Petition # 86-026 c

Purpose of zoning change TO PROVIDE A MEETING HALL FOR THE
KNIGHTS OF COLUMBUS, A CHURCH AFFILIATED MENS GROUP.

DATE: April 24, 1986
PETITION NO.: 86-26(c)
PETITIONER(S): Knights of Columbus

REQUEST: Change from R-15 to R-15MF(CD).

SITE LAYOUT

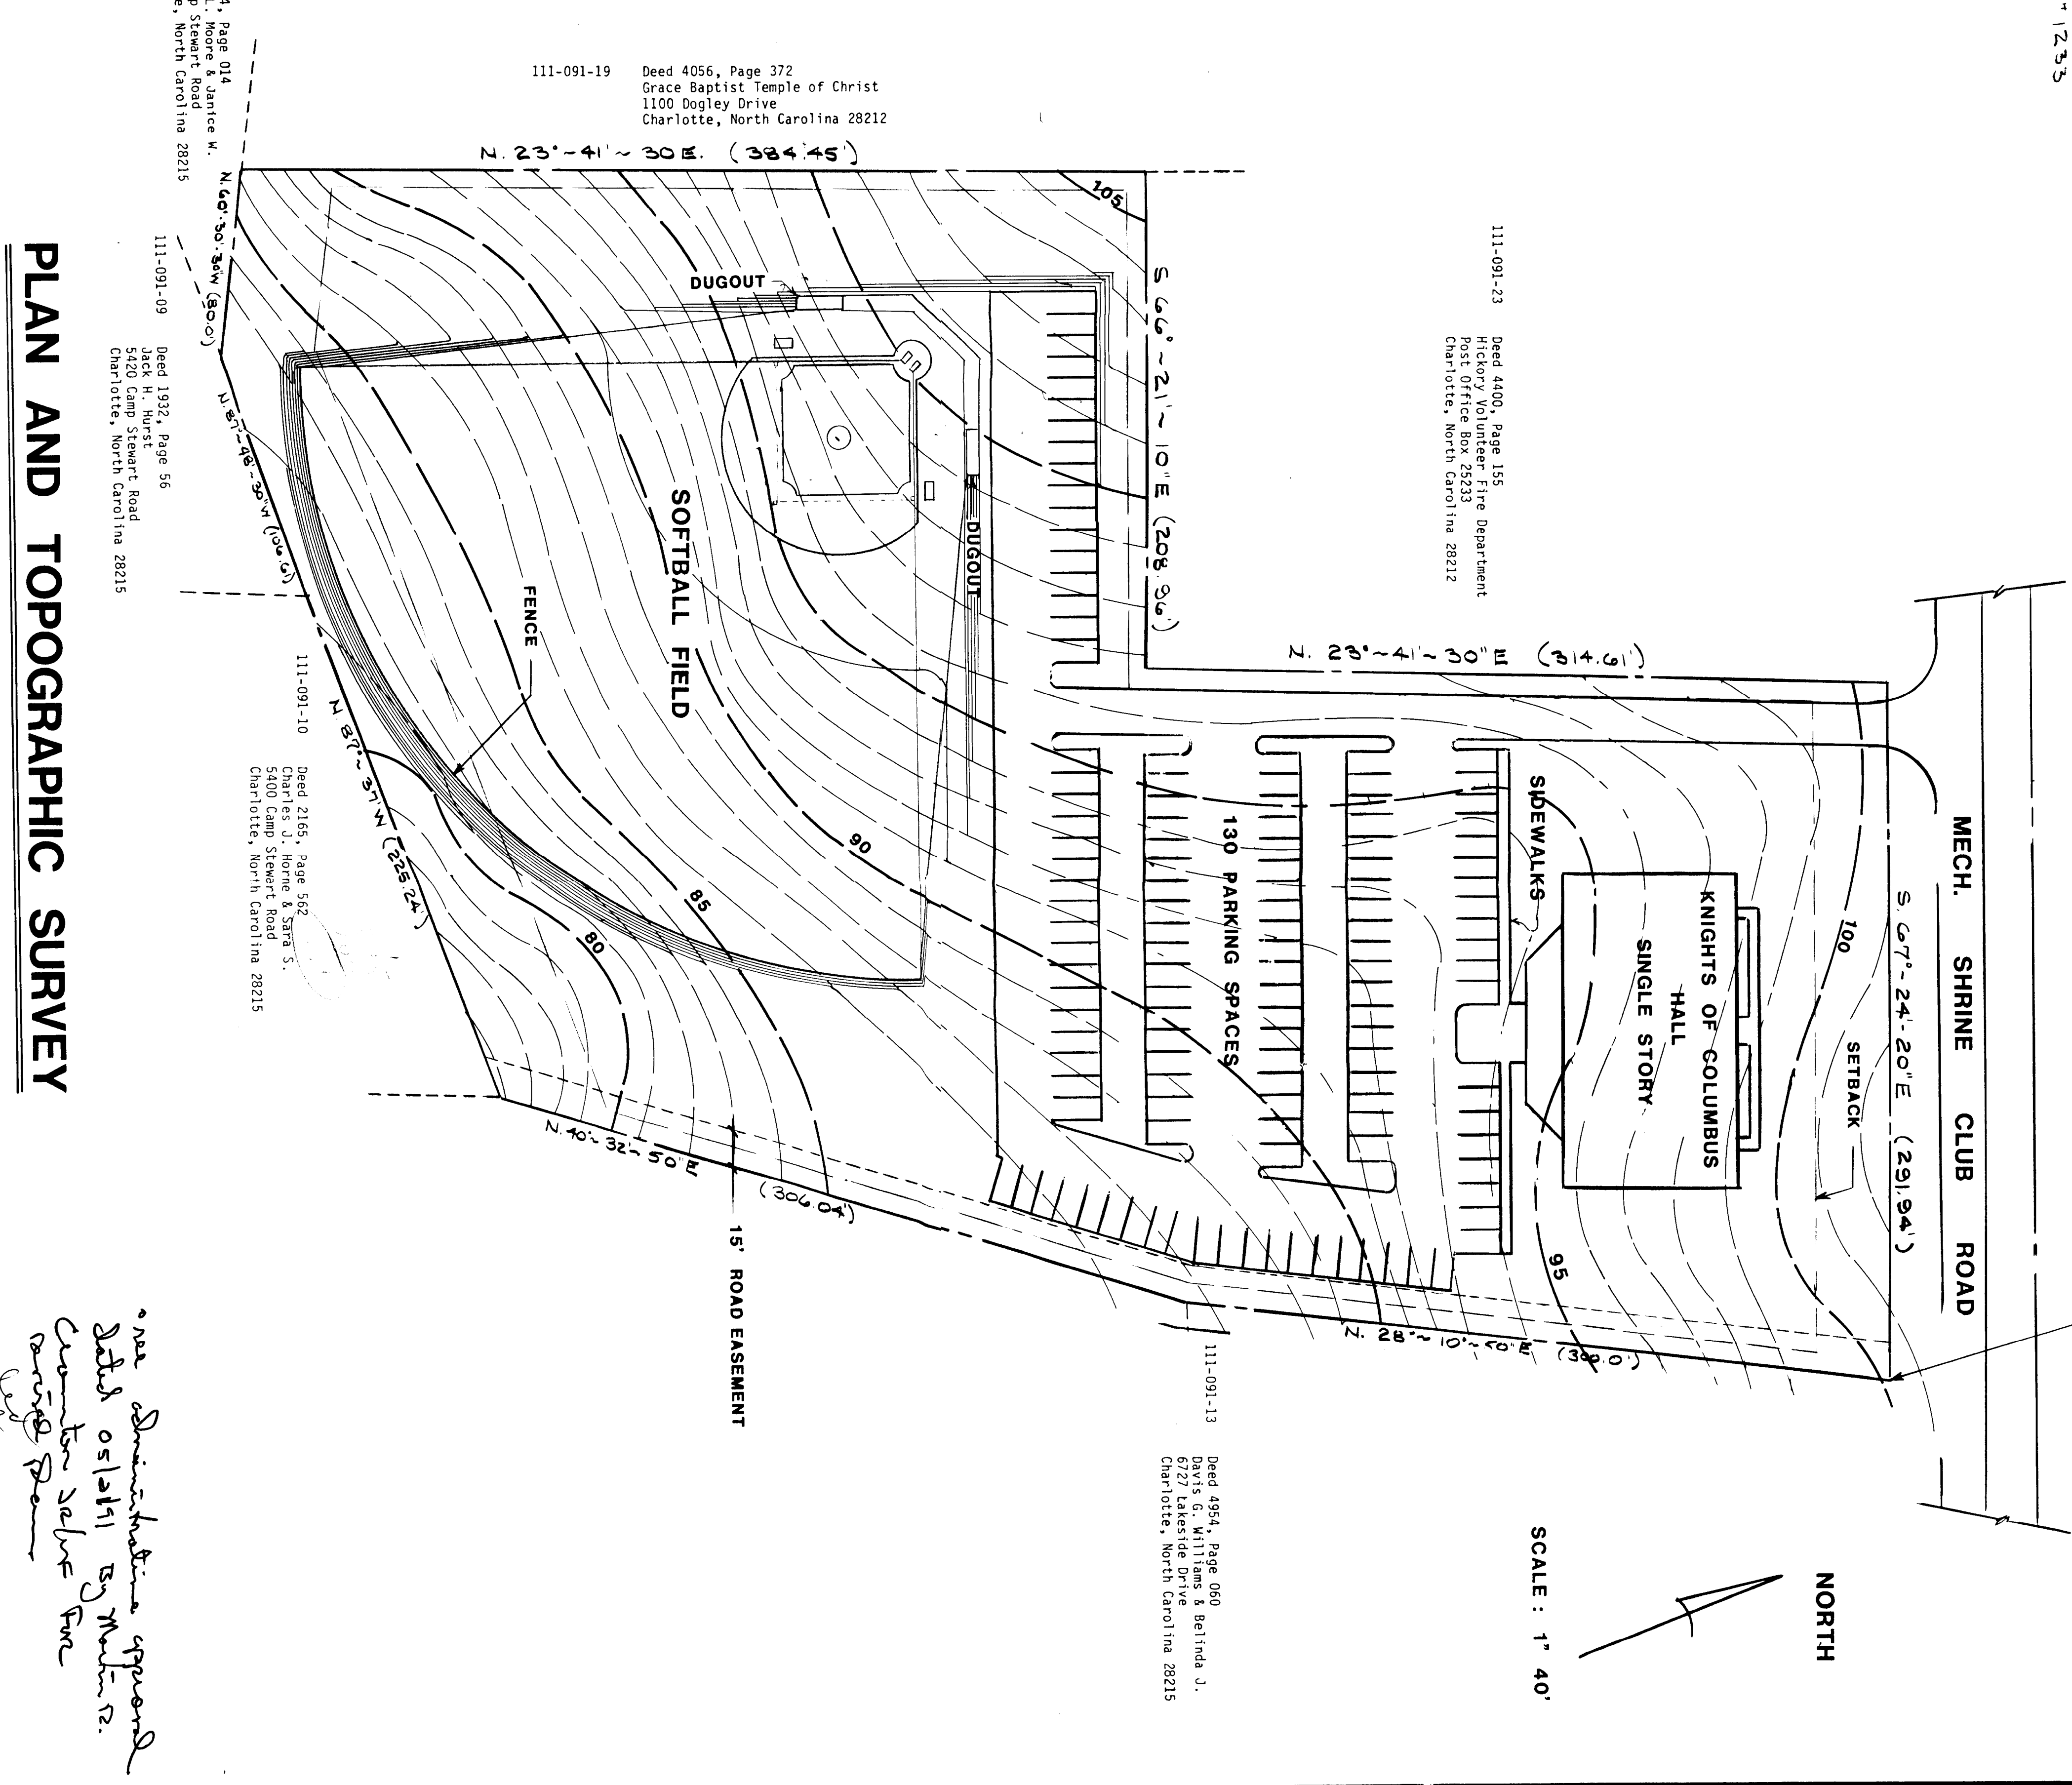
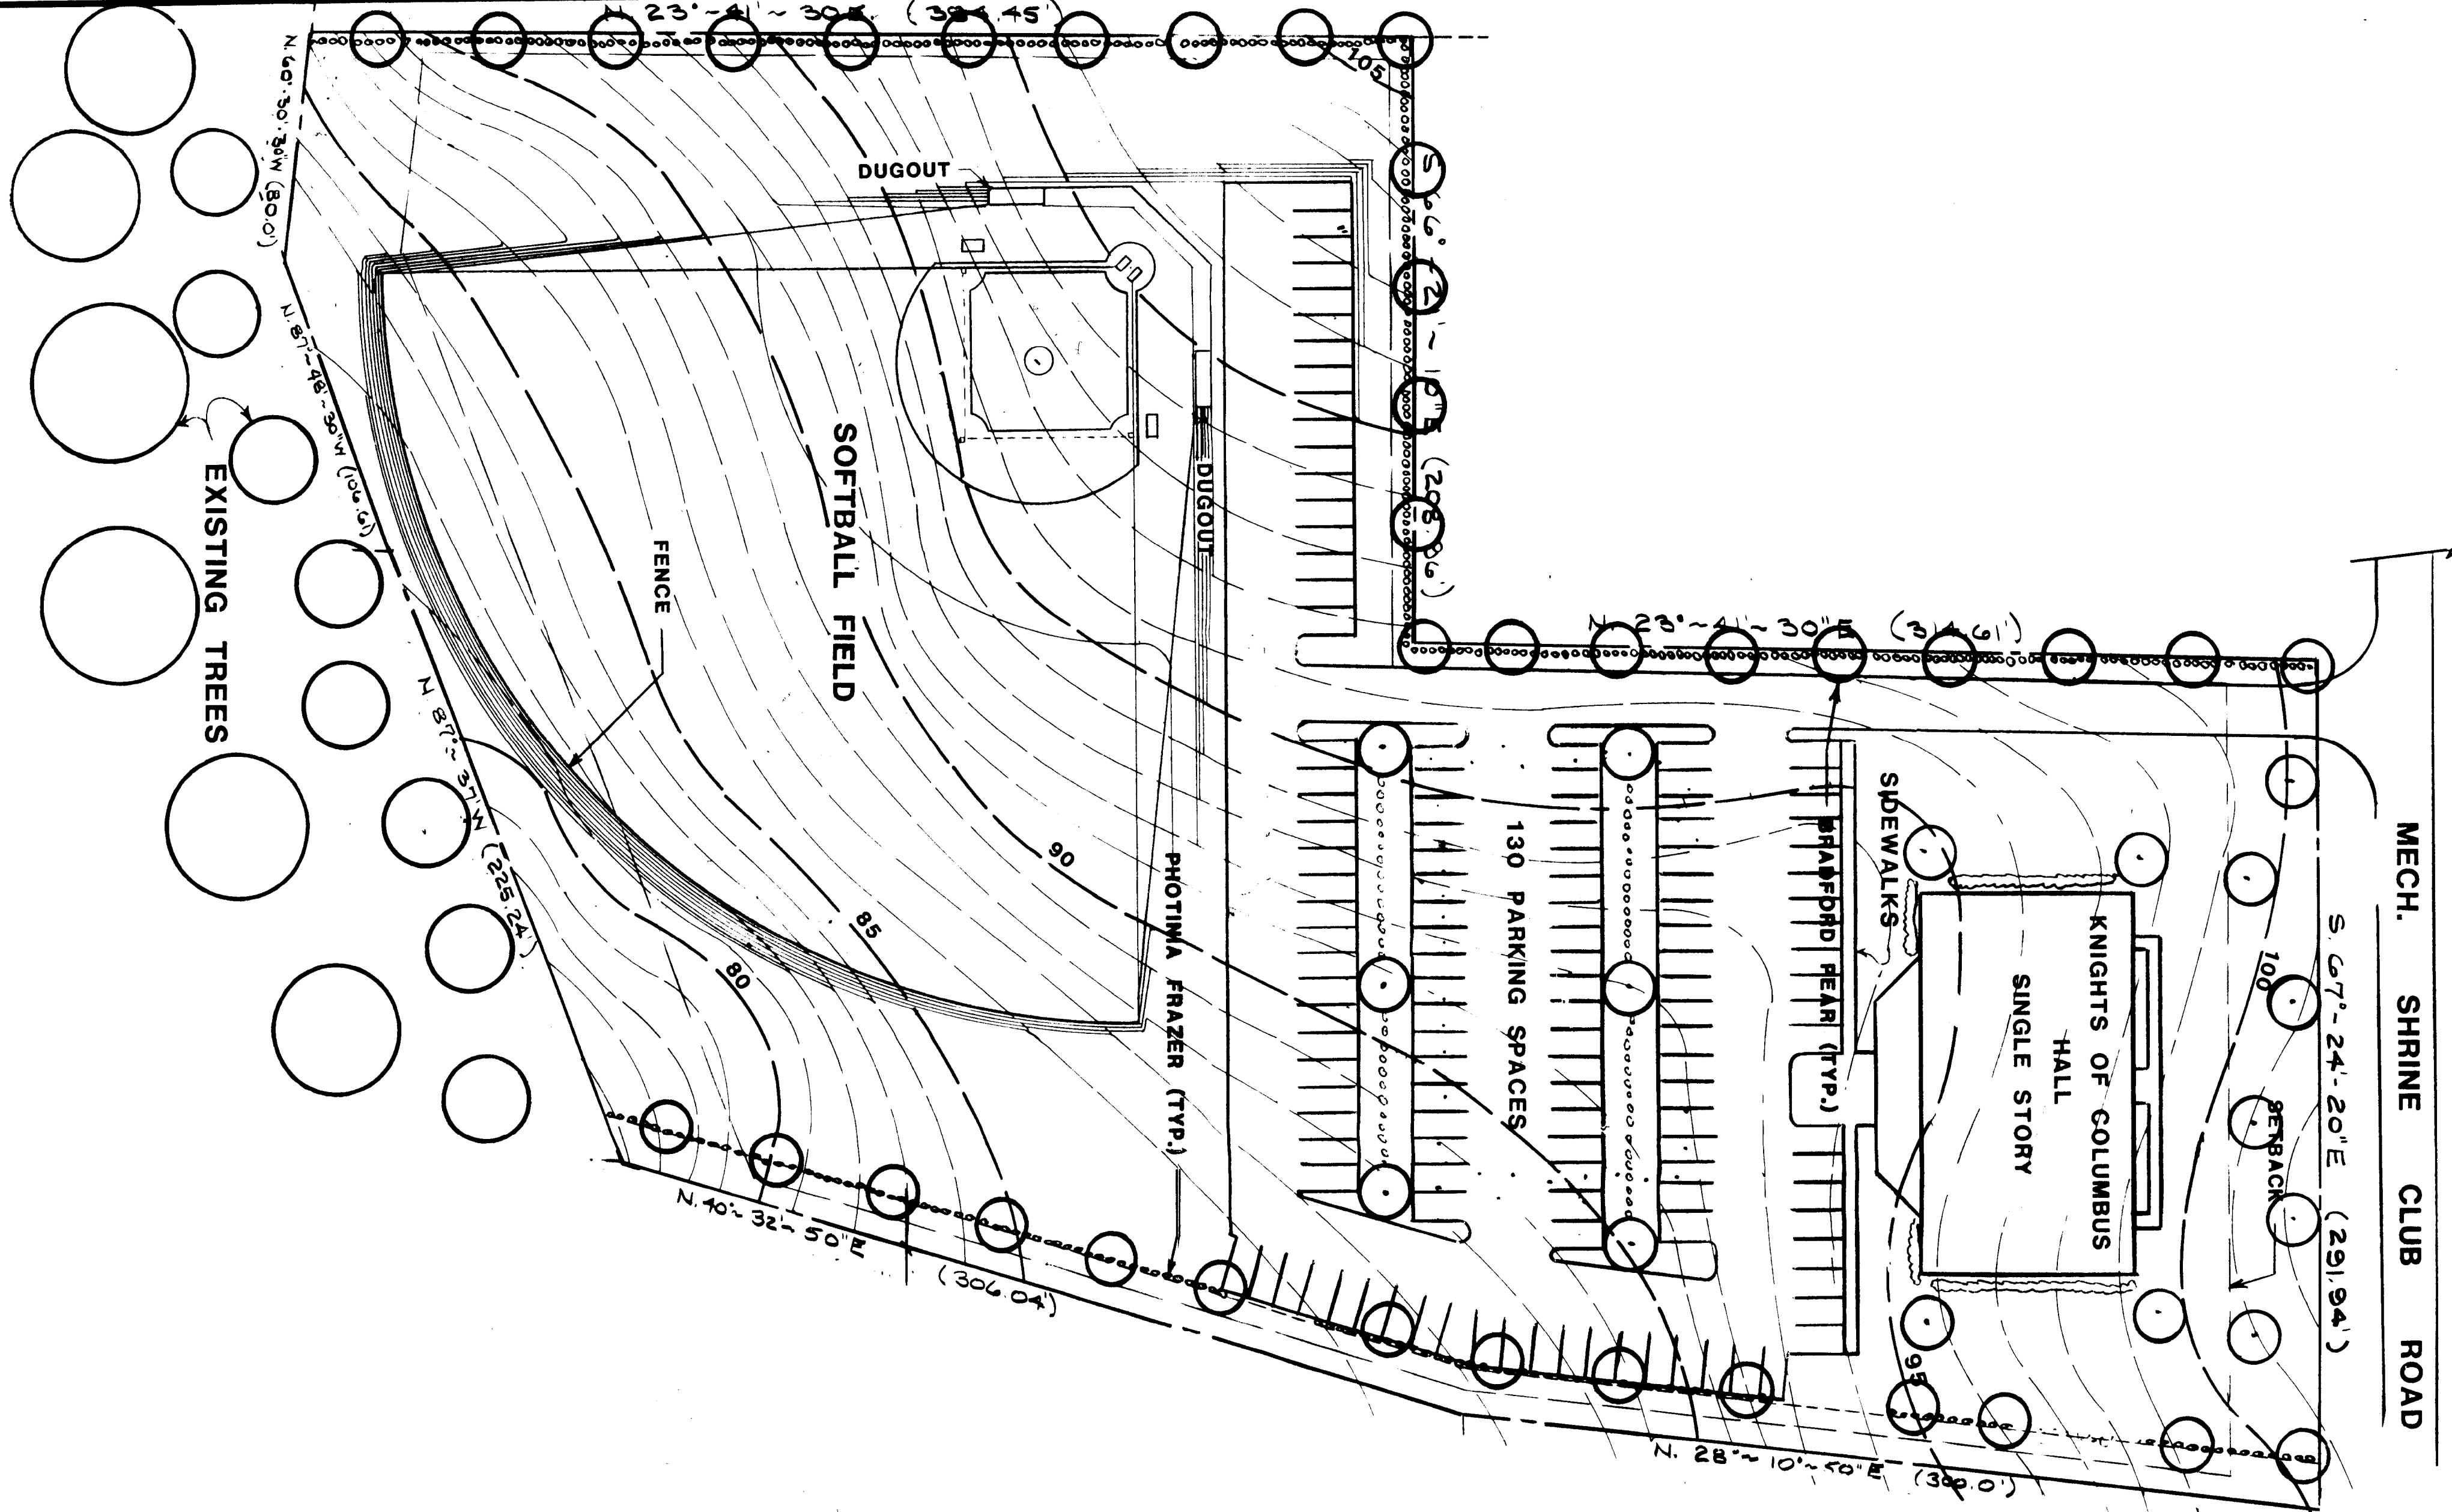
2. Pre-Hearing Departmental Comments (Summary)
 1. County Engineering. Comments were unavailable as of the preparation of this report.
 2. Building Standards. The only problem noted was that one driveway is shown to be straddling a property line and it is necessary that the driveway be entirely on the petitioner's property.

6. Early staff concerns about the site plan were corrected by the petitioner. Among these are the fact that staff felt the plan would be better by "flip-floping" the building and parking areas such that the building would face the street with parking tucked in behind it. This better helps to relate the site to the area. In addition, the plan filed with the application showed one driveway access actually straddling the property line and that very definitely needed to be entirely within the property boundary limits. (That driveway was dropped from the plan.)
